5948\_301\_McMullenSubmission.docx

RE: Sancrox Quarry Expansion Project – Project Number – SSD-7293

This submission has been prepared on behalf of Peter Laurence Beaumont and Anne Veronica Beaumont, the registered proprietors of Lot 1 DP555095, No. 78 Sancrox Road Sancrox, being the executors of the Estate of Daniel McMullen (McMullen Estate). This landholding adjoins the current and proposed Sancrox Quarry on the quarry's southern boundary.

Figure 7 Location of SAT sites, koala sightings and  
distribution of core koala habitat

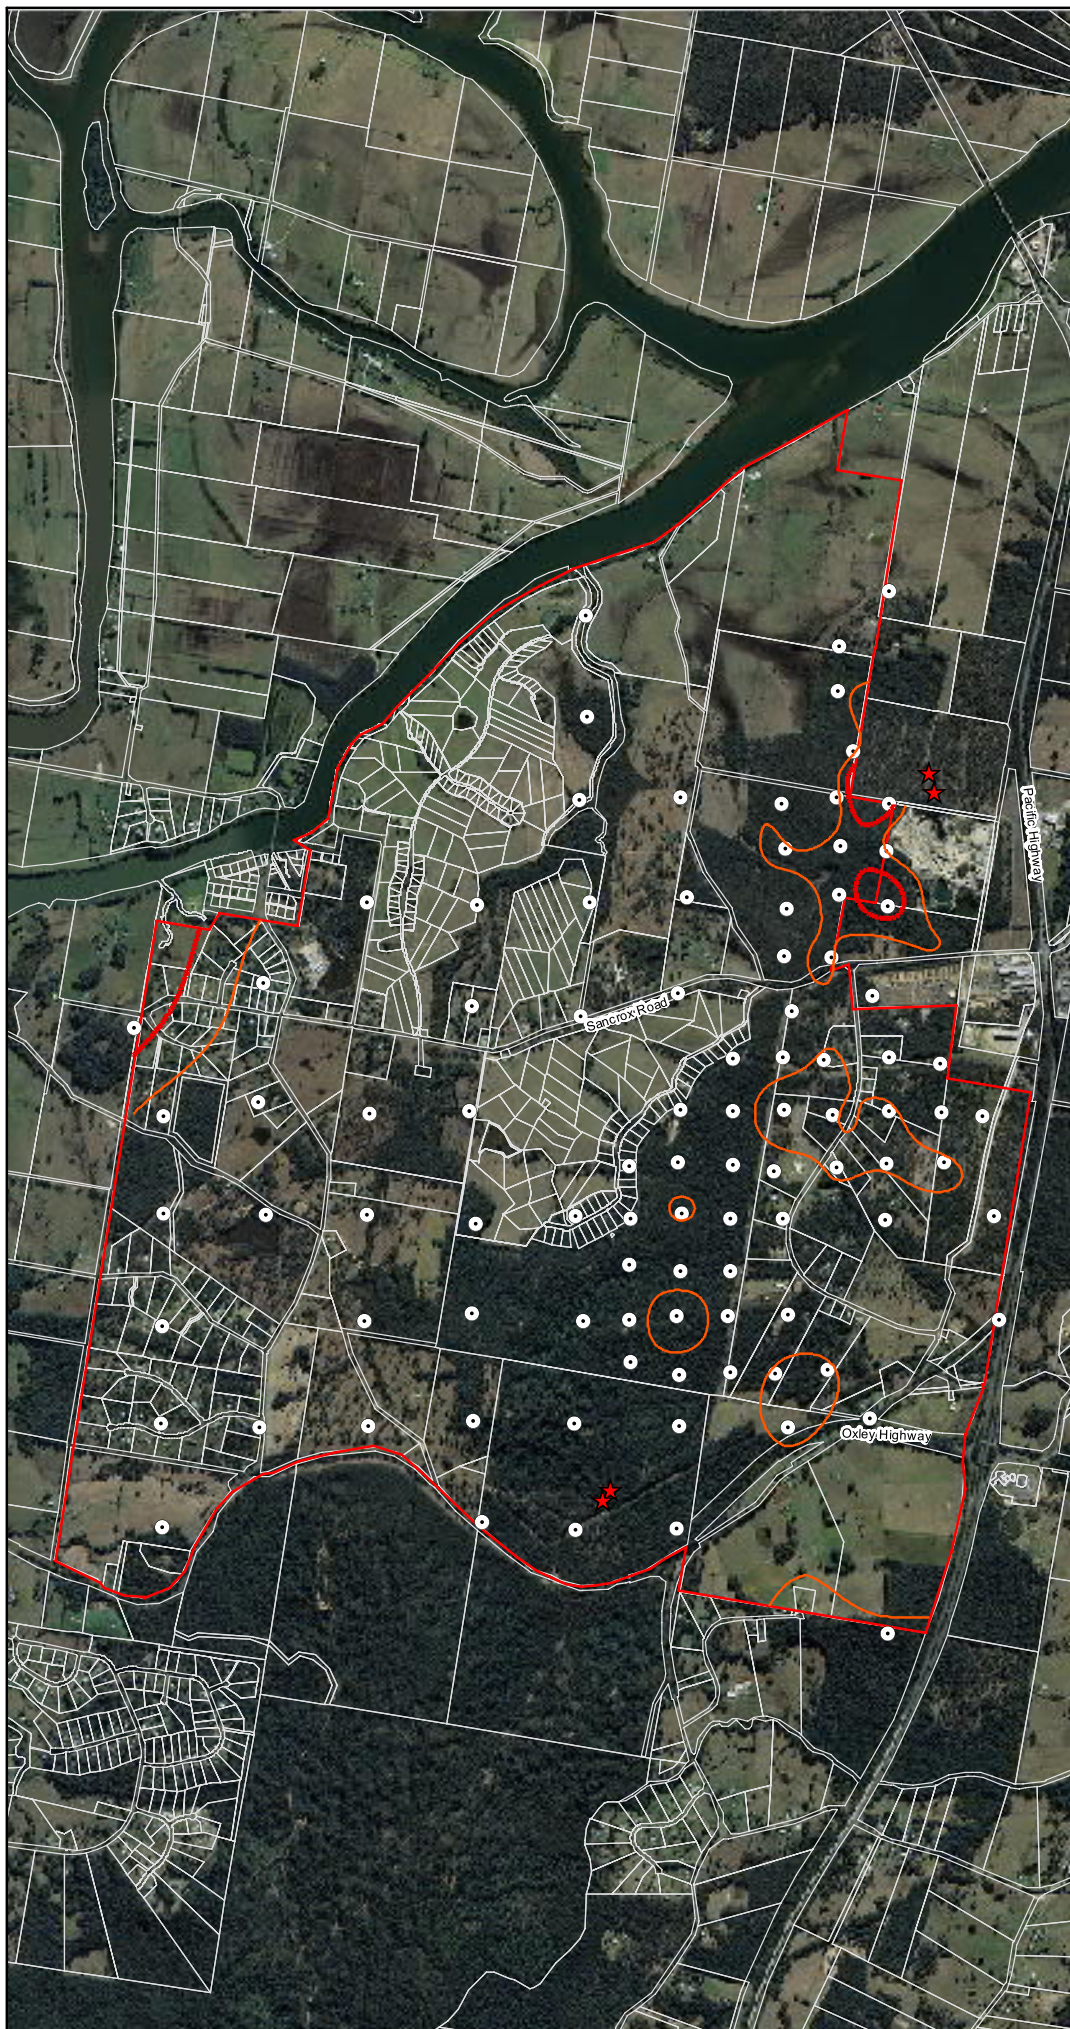
- Previous ecological studies on the McMullen Estate property to the south and the Dunn Family property to the north off the subject site, have established the presence of Koala. Koala Plans of Management (KPoM) were prepared in respect of both adjoining properties on the basis that the area adjoining the proposed expansion of the quarry was considered to be Core Koala Habitat. The

KPoMs approved generally accord with Biolink's 2011 assessment of core koala habitat in the Greater Sancrox area. (Refer Attachment 3, Sheet 1)

The ecological report with the EIS acknowledges that the site is "potential koala habitat" in accordance with SEPP 44 and that 805 records exist of koala in the search area but does not reference the approved KPoMs adjoining the southern and northern boundaries of the proposed quarry expansion. This omission is a further fundamental flaw in the ecological assessment contained in the EIS.

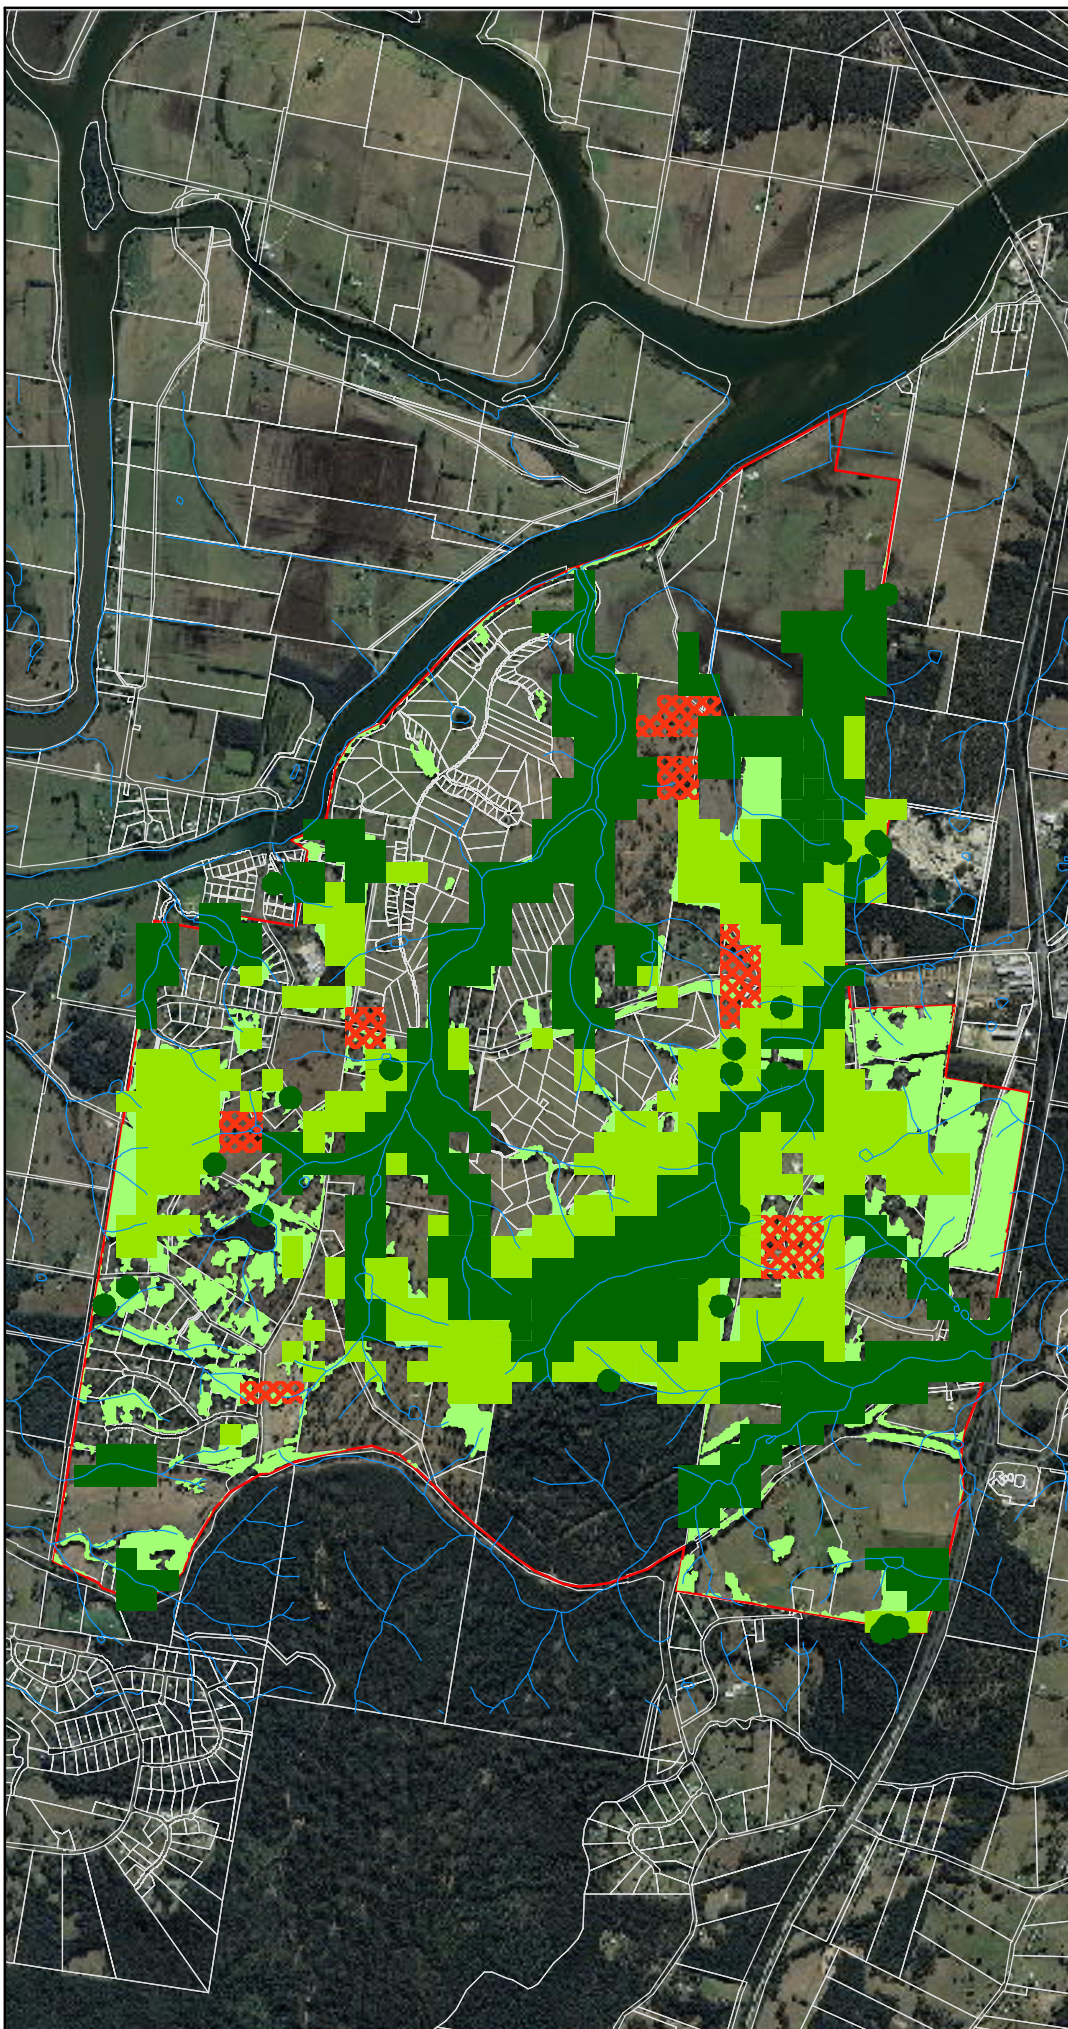
In terms of ecological values, the area proposed for quarry expansion was mapped as either "irreplaceable" or be "value managed". (Refer Attachment 3, Sheet 2)

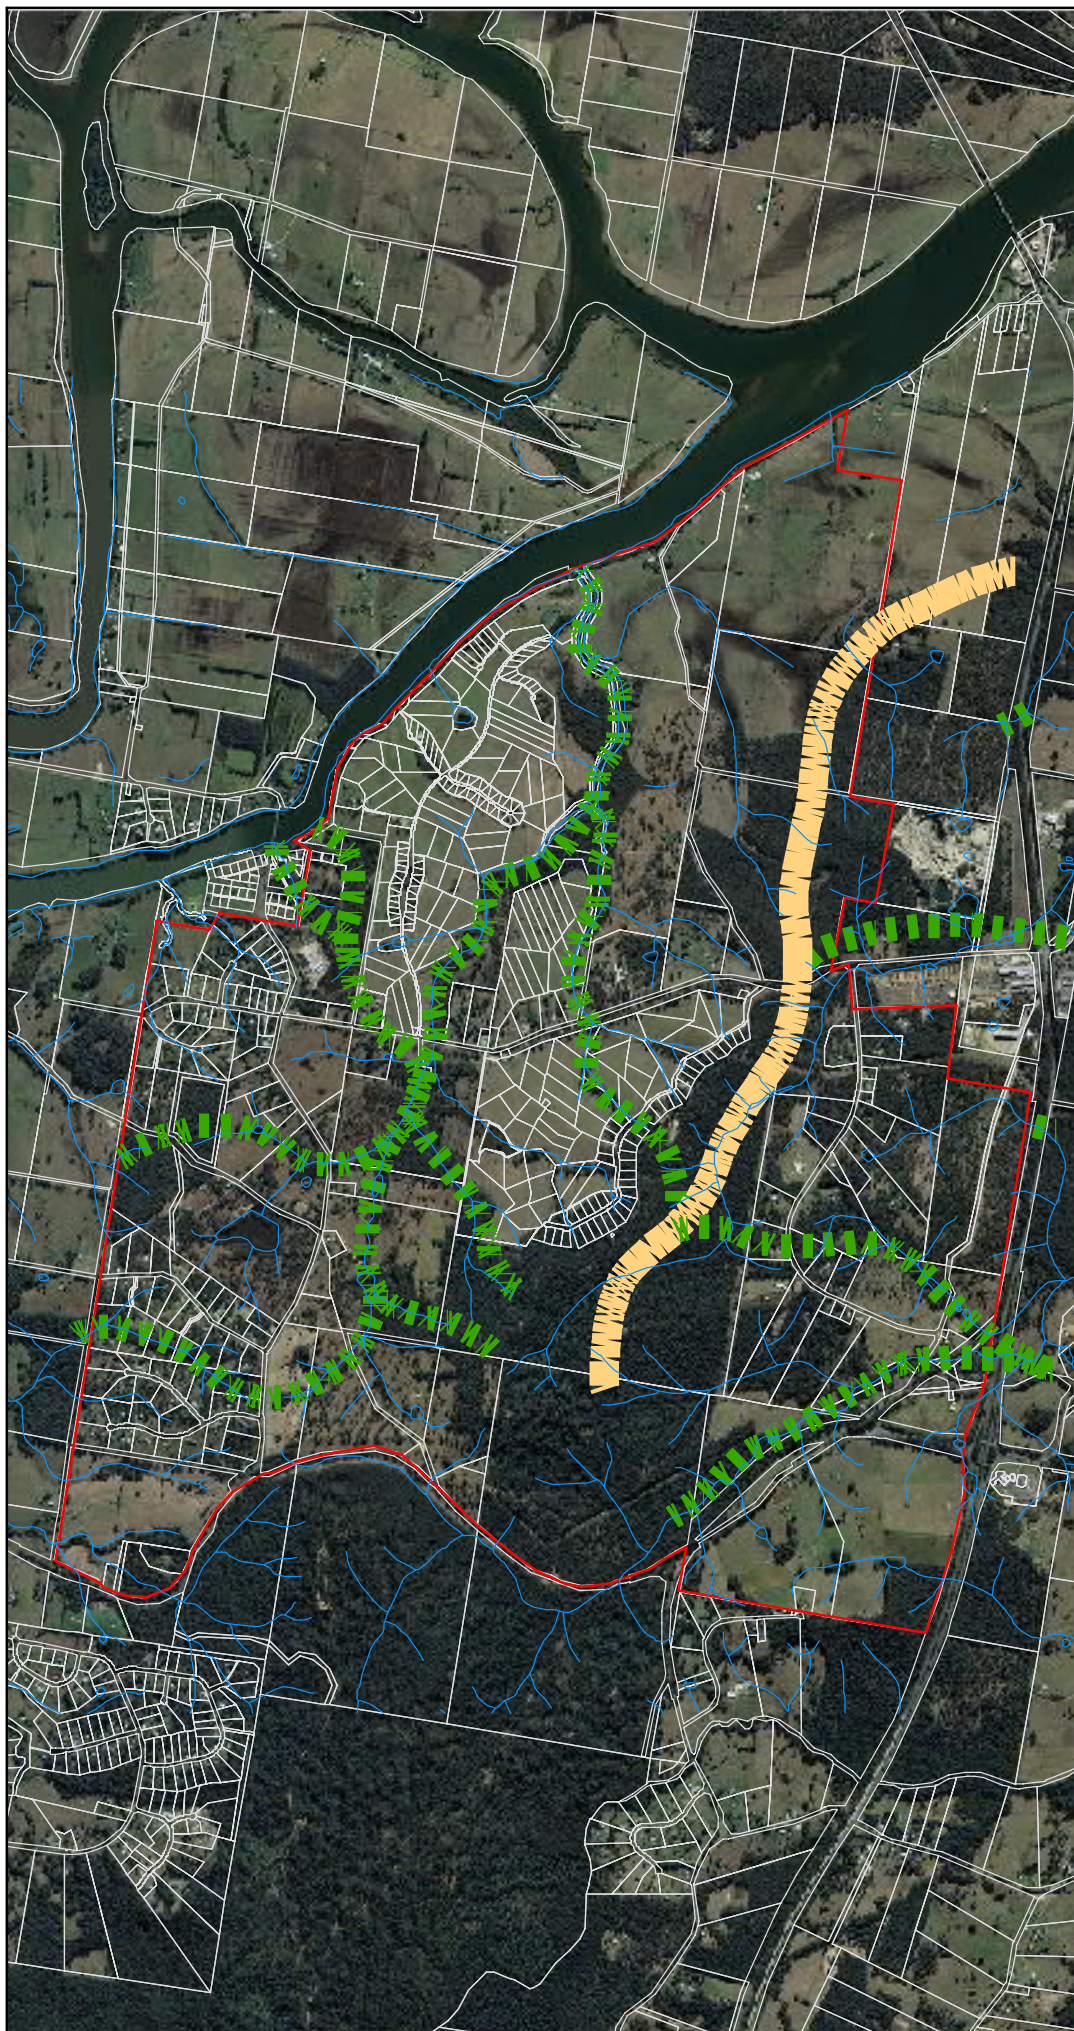
- The EIS and associated biodiversity report makes limited references to previous ecological assessments completed as part of various urban growth and development proposals in the immediate area and including this site.
- The report assessments outcomes differ significantly from those carried out previously. The 2011 Biolink report prepared for Port Macquarie-Hastings Council (PMHC) as part of the Greater Sancrox Structure Plan, identified the majority of the area proposed for the quarry expansion as being part of a Sub-regional Corridor. (Refer Attachment 3, Sheet 3)
